Summary of comments made by Philip Britton on behalf of Greatford Parish Council (Interested Party 20034891) & MPAG at Issue Specific Hearing 4 27/09/ 2023

Comments made regarding the establishment of grassland across the proposed Mallard Pass Solar Farm.

Plate 9: Establishing Grass Mix Under PV Drip Line³¹³²

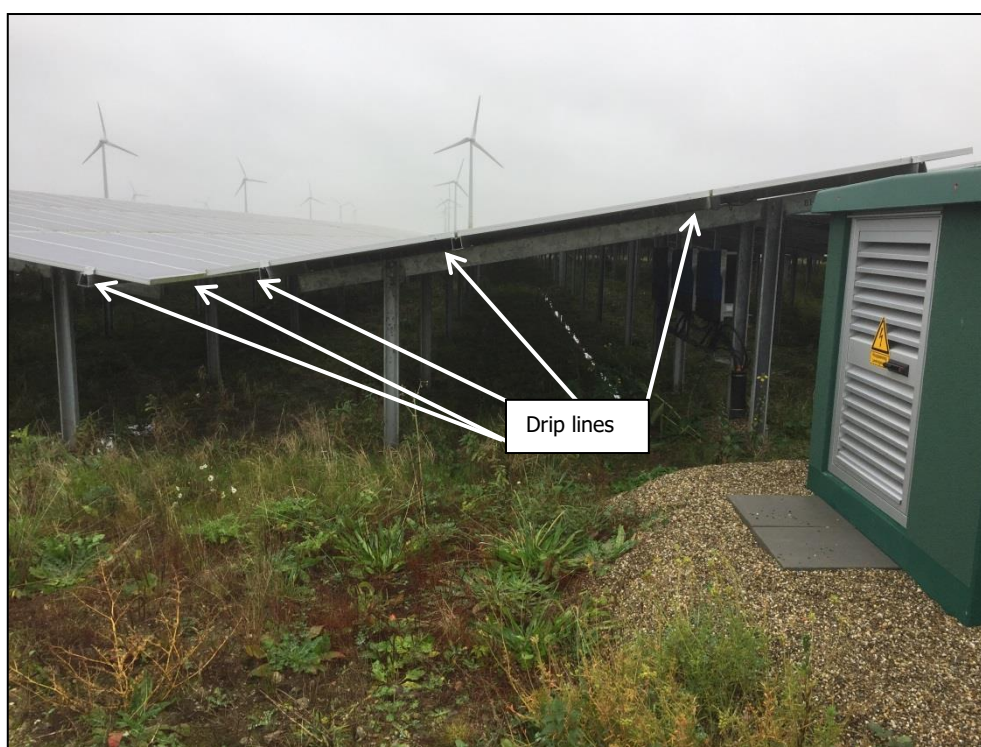
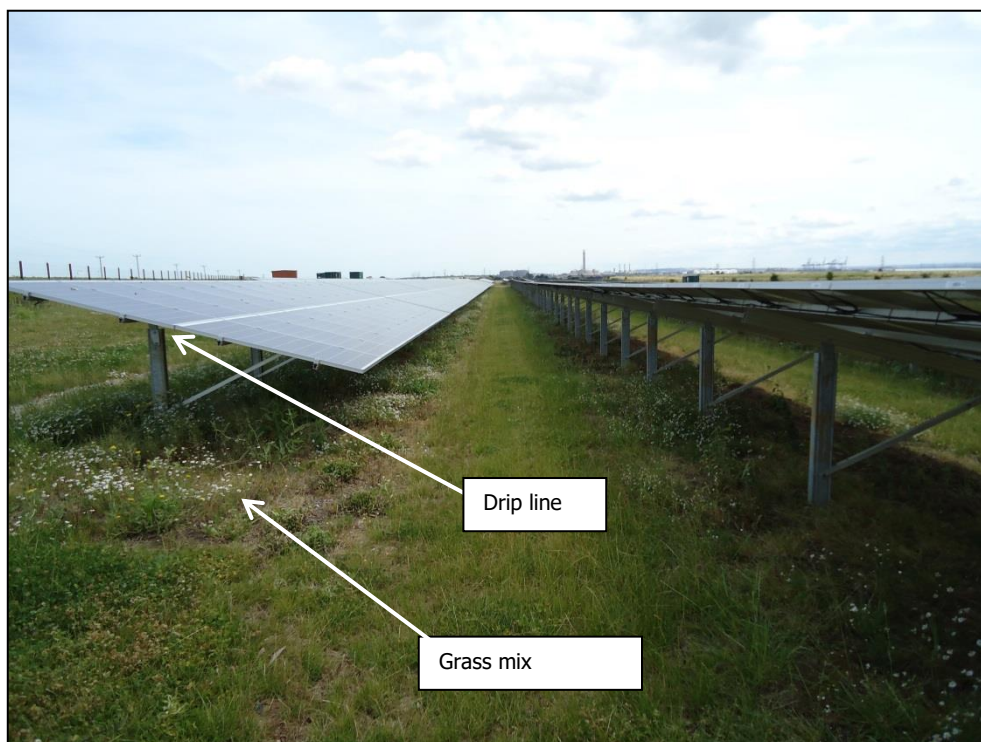
The concern around most of the species in the Amoresgate seed mix is that they are slow growing, shade tolerant species, which is a good thing (as they will be growing under panels), but these species need a lot of time to establish, to establish adequately and thoroughly so that benefits of reducing flood risk by increasing water infiltration rates into the soil are present before construction starts.

So our point is we would like to see Grassland established at least 12 months, maybe 18 months before construction.

I cannot see, as an agronomist with 30 years experience, how The applicant is going to establish the grass properly on an ad hoc basis when construction allows.

Depending on what the situation is, which season it is drilled in, the grass needs a good 12 months to establish (basically a full growing season) to establish properly so that it will be there to protect the soil, the land and reduce the flood risk for the following 60 years.
